DECISION DELEGATED TO HEAD OF PLANNING

Application No: H13-0507-24 **Applicant:** BLM Builders Ltd
Proposal: Residential Development - 2 Dwellings - Outline Approval H13-0651-20
Location: Rear Of War Memorial Seas End Road Moulton Seas End
Terminal Date: 5th November 2024

J185-PL 17

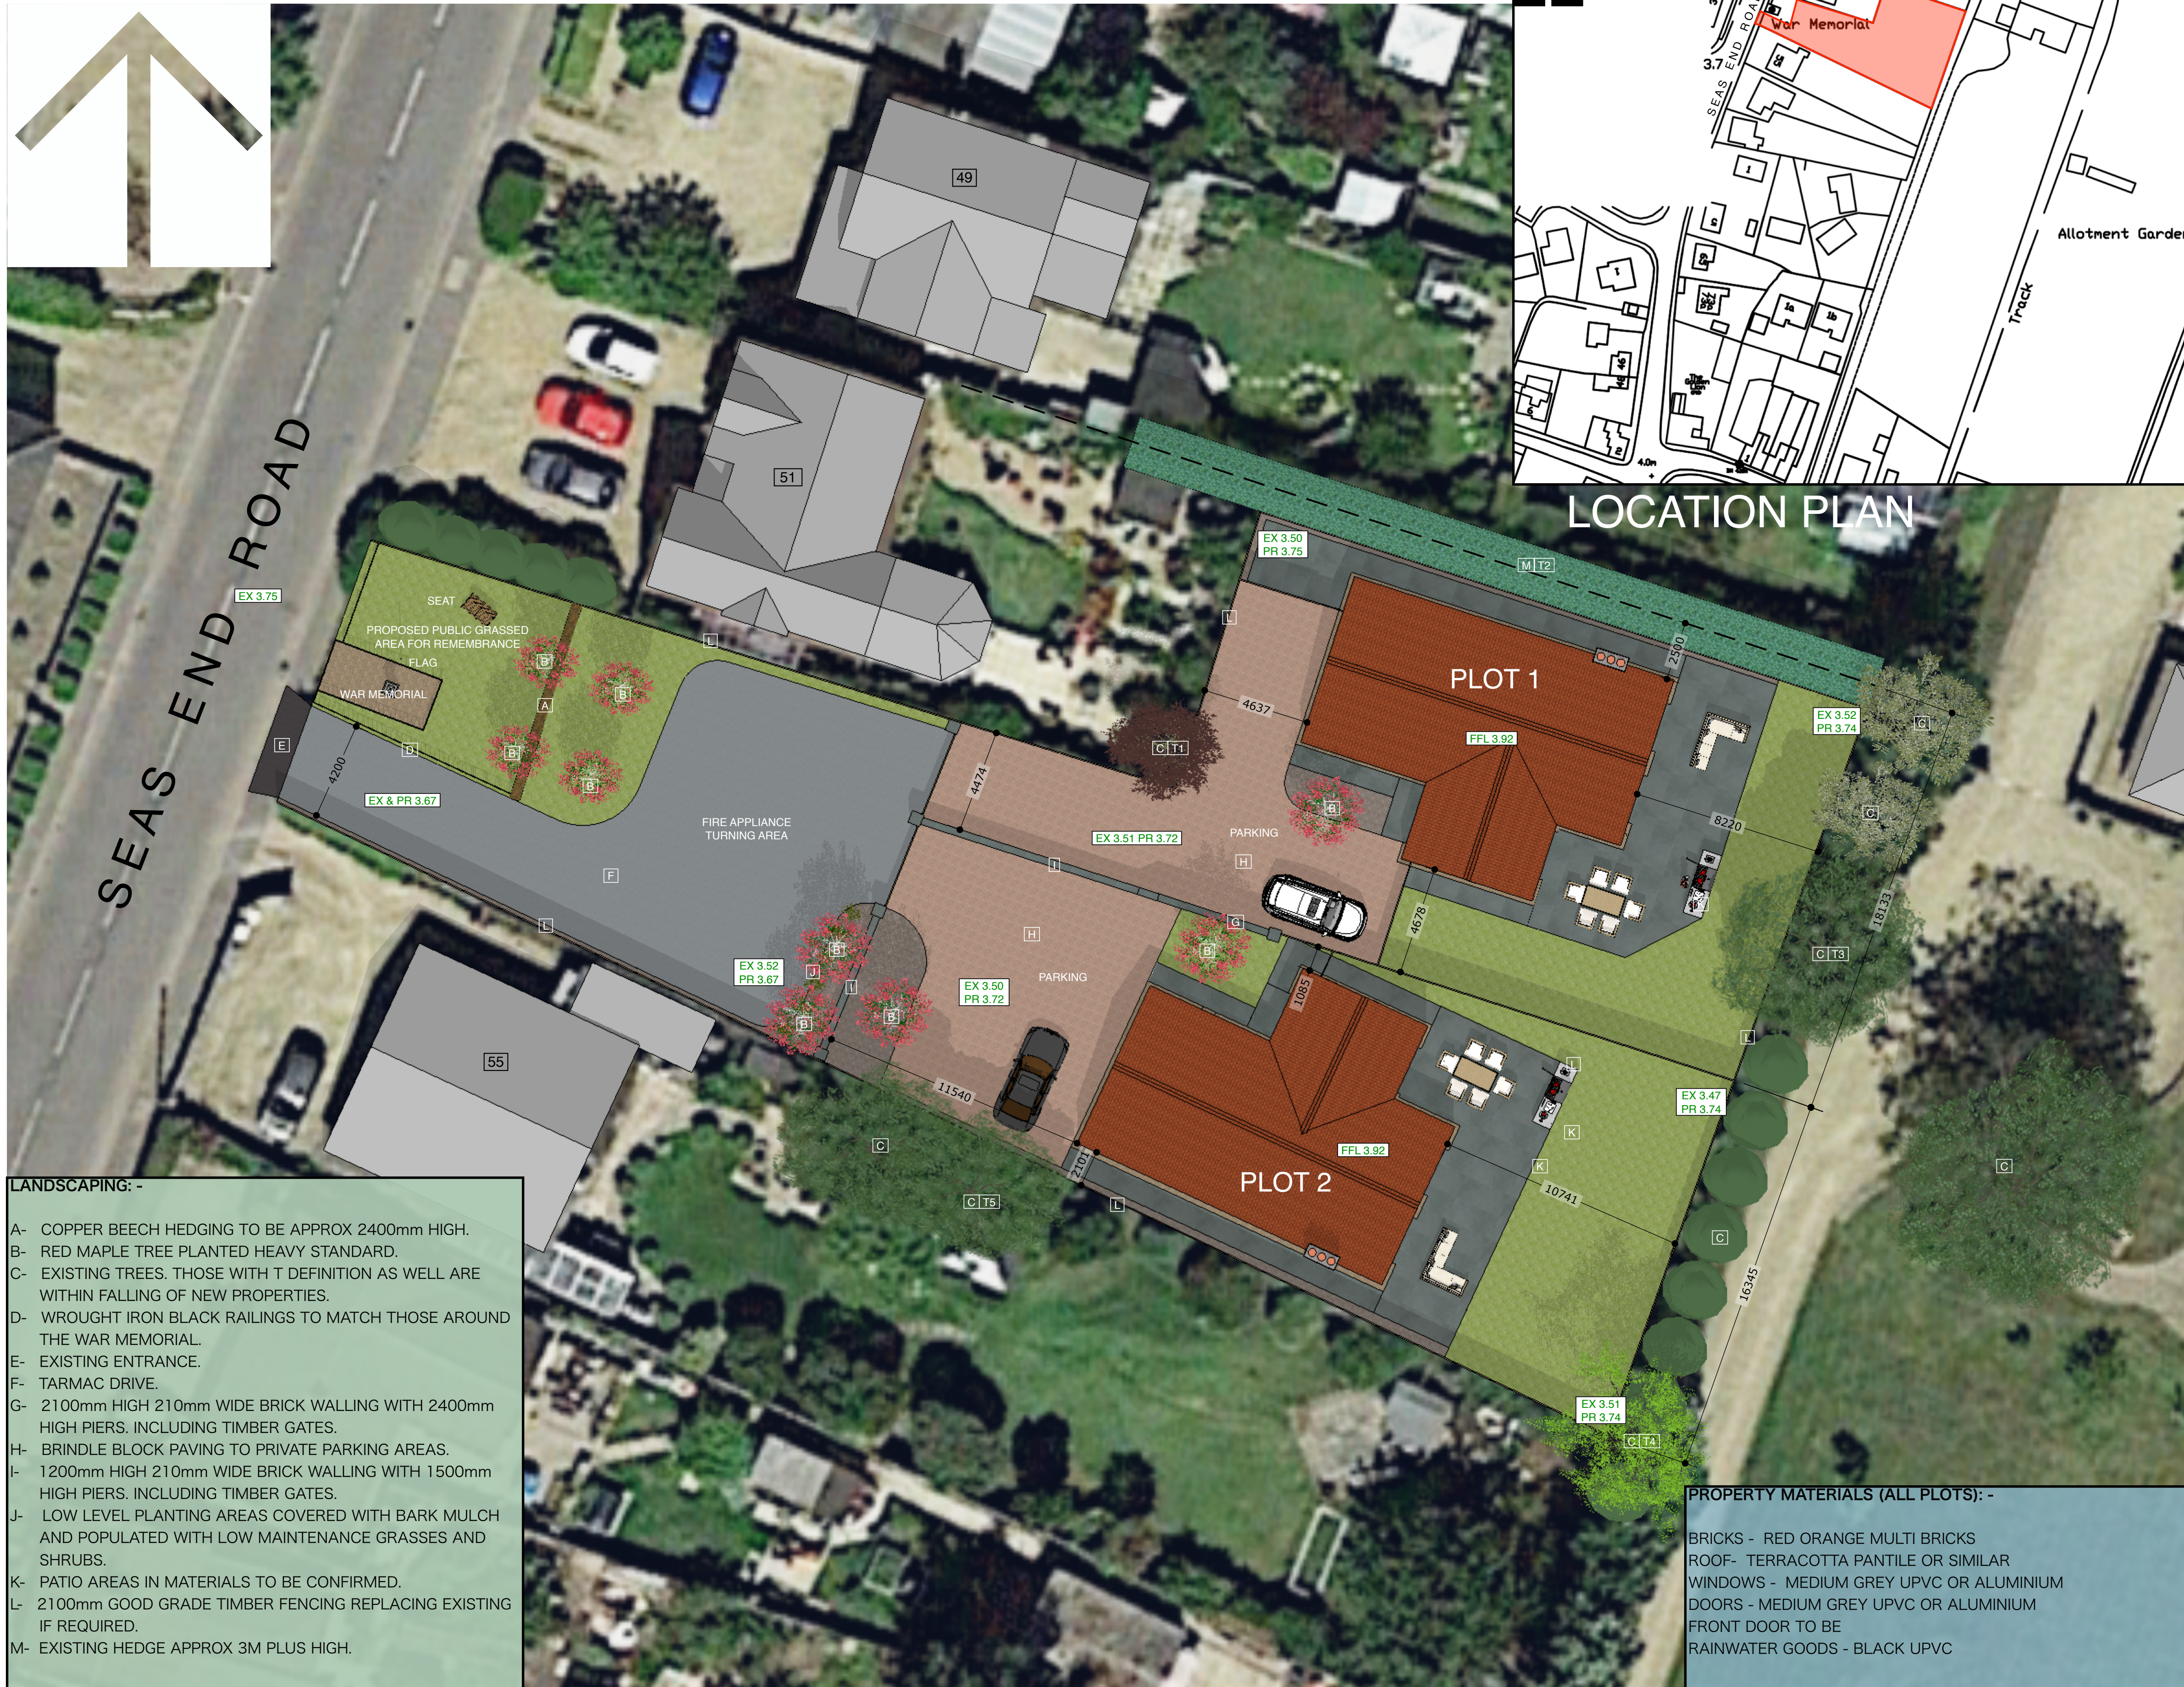
First Response (24 June 2024): Visibility to be demonstrated in accordance with Manual for Streets.

Second Response (03 September 2024): Visibility has not been demonstrated as previously requested.

Third Response (31 October 2024): The parking and turning detailed is acceptable for the size of the proposed dwellings. The proposal will not have an adverse impact on the public highway. Highway condition 13 and highway informatives 3 and 8 are recommended.

The proposed bungalows would be served via a new vehicular access from Seas End Road. Lincolnshire County Council's highways and sustainable drainage team have confirmed they have no objections to the proposed layout, following the submission of details related to the proposed visibility splay. The highways team have recommended a condition which would require the visibility splays to be maintained. There is sufficient room for parking and turning within the site for both bungalows.

J185-PL 17C

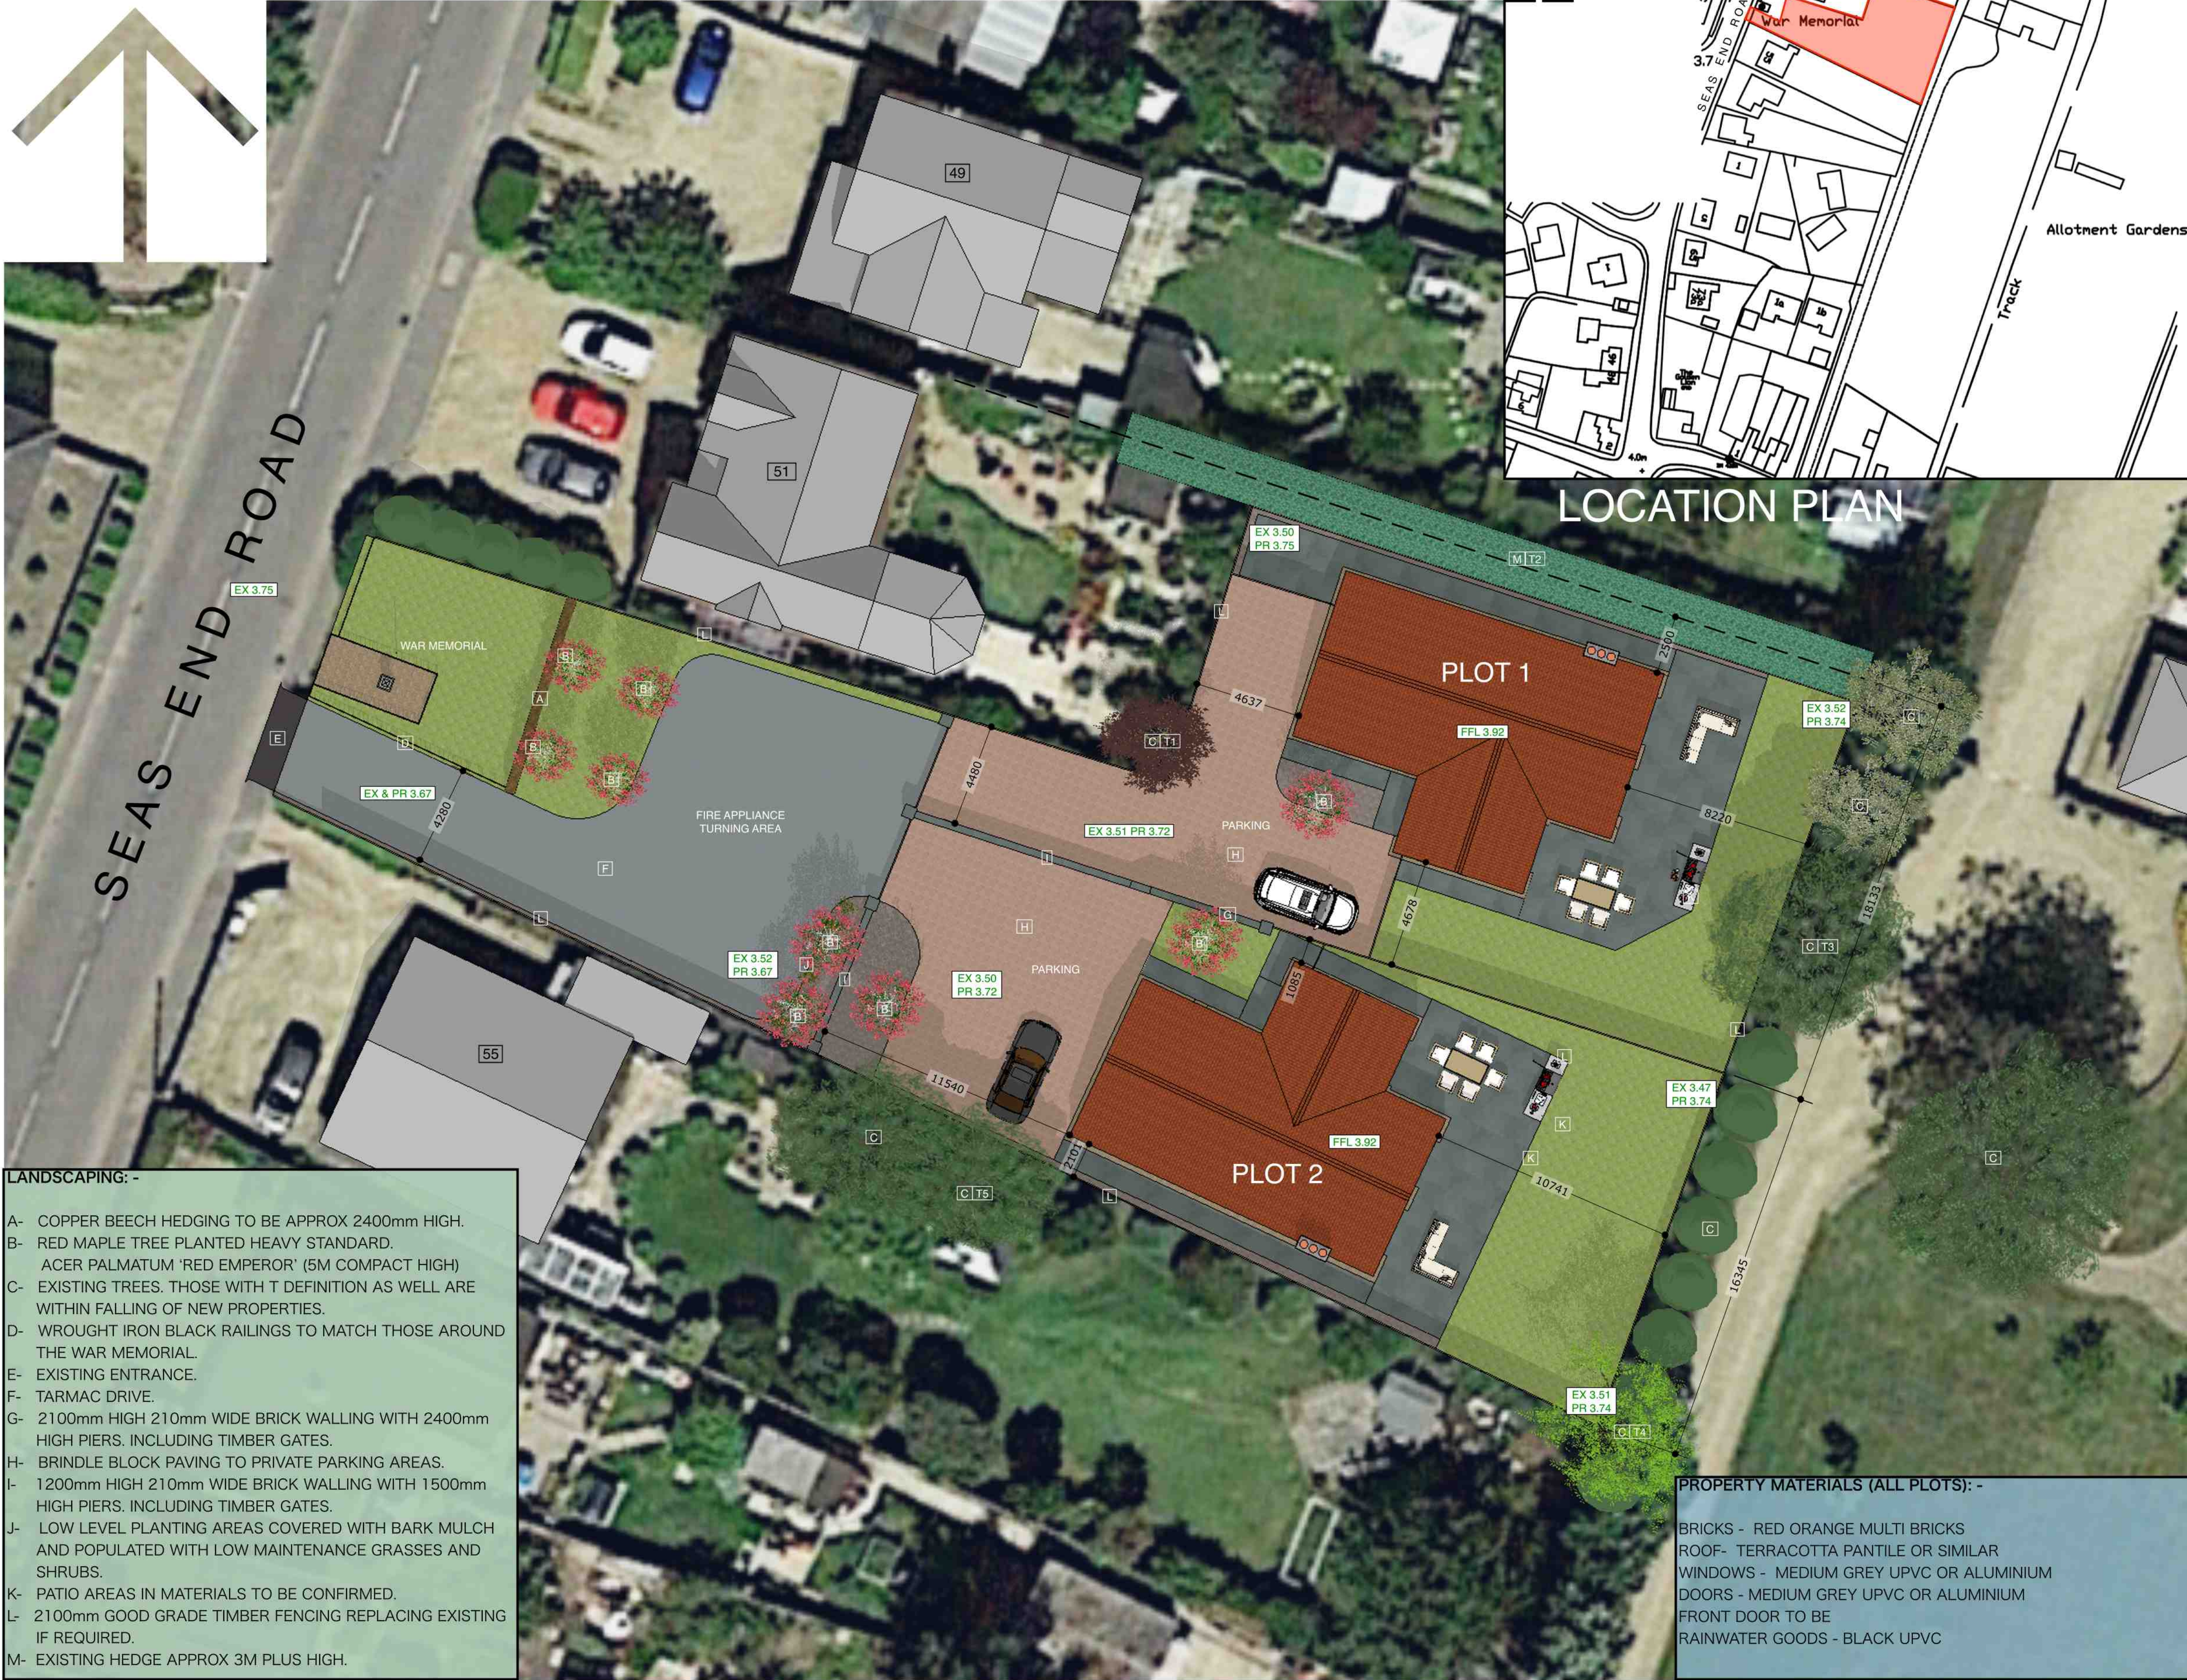
- The proposed red maple trees would cause overshadowing when grown. British native trees should be proposed instead.
- The copper beech hedging at the front of the site would be above 1.8m in height.

It is noted that the public representation sets out a concern with the loss of trees as a result of the proposals and also with potential overshadowing as a result of the proposed tree planting. None of the trees within or adjacent to the site are subject to a Tree Preservation Order and as such the trees could be removed without planning permission. Several red maple trees are proposed to be planted within the site. These trees have been reduced to a smaller variation during the determination of the application and as such the trees would not be as tall as previously proposed. It is not considered that the trees would result in an unacceptable degree of overshadowing though as there would be dappled light through the trees and they would not be positioned to block a significant amount of light to neighbouring dwellings.
